About the application

Application number: 2025/92242	
What is the application for?:	Reserved matters application (including consideration of appearance, scale and I
Address of the site or building:	Land off, Hermitage Park, Lepton, Huddersfield, HD8 0JU
Postcode:	WF2 7UA

Drawing Title
Tree Protection Plan 2 of 2

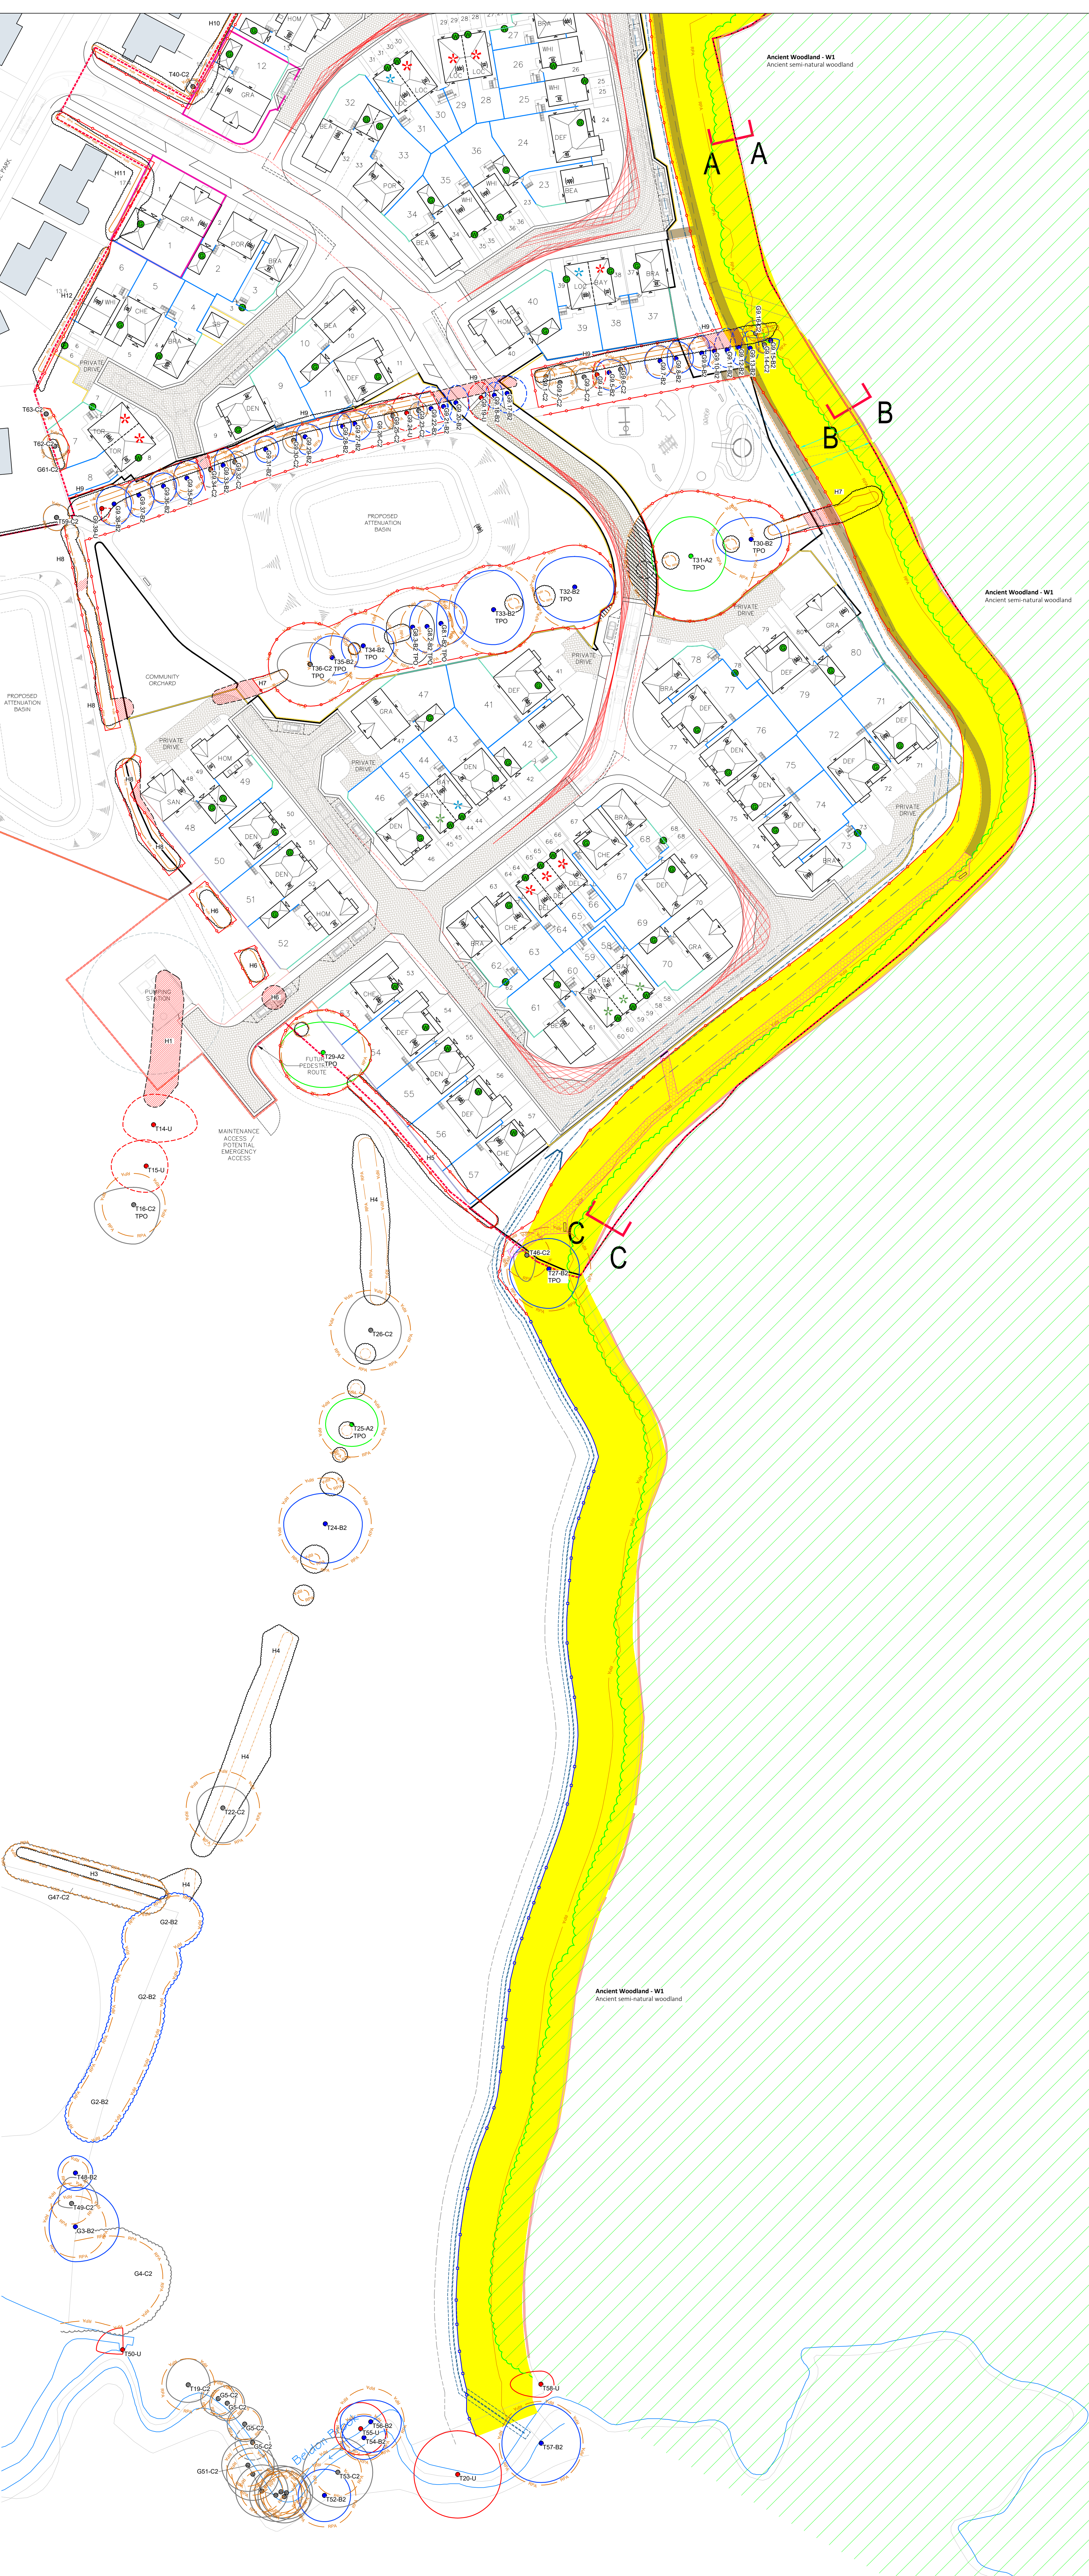
Type of comment: An objection	
Do you wish your comments to be published on the website anonymously?	Yes
The proposed buffer between the development and the ancient woodland is insufficient. The developers previous information says there would be a 20m buffer, however it is unclear if they are proposing now reduced it to 15m. A much larger buffer zone is needed to protect the woodland and wildlife and to retain the character of the area.
